CITY OF ALBUQUERQUE

January 16, 2013

**Re: Southwest Capital Bank,
Grading & Drainage Plan
Engineer's Stamp dated 1/11/13 (J13/D093)**

## f. HYDROGRAPH CALCULATIONS

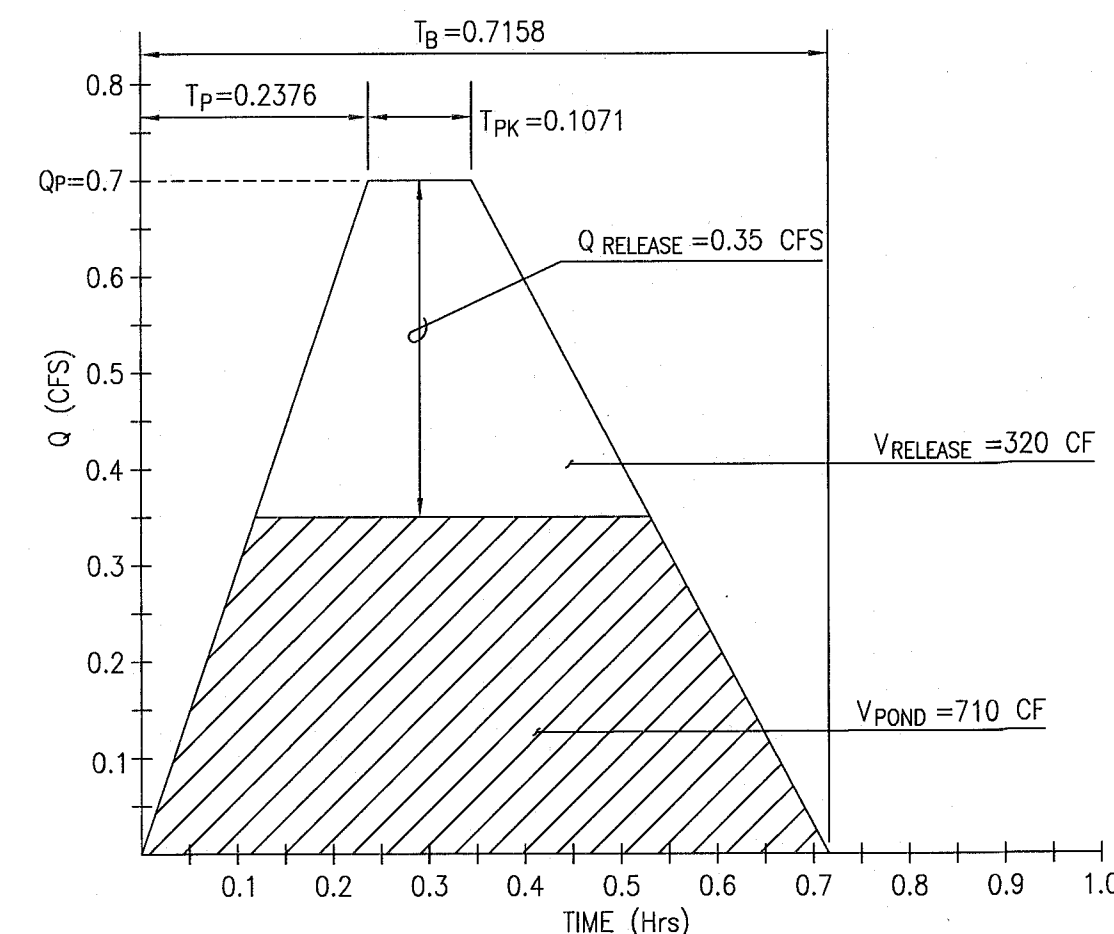
- All landscape areas are to be depressed. At the NW corner why not get rid of the berm, depress the landscape and move the basin line to the back of curb and add a sidewalk culvert.
- Flows are not allowed to exit the site over a public sidewalk. The flows from basin 1 and part of basin 2 seem to be flowing over the public sidewalk.
- Are the flows in basin 2 retained or detained. If retained where is the emergency over flow and at what rate? If detained what are the roof drain bubblers attached to for exiting flows? Would the roof drain bubblers function better if surrounded by gravel and not concrete?
- Are the roof drains attached directly to the drainage system?
- The second graph shows that the first flows are exiting at time $t = 0$ hrs and retaining at $t = .15$ hrs. Is the table labeled wrong?
- Provide pond volume calculations.
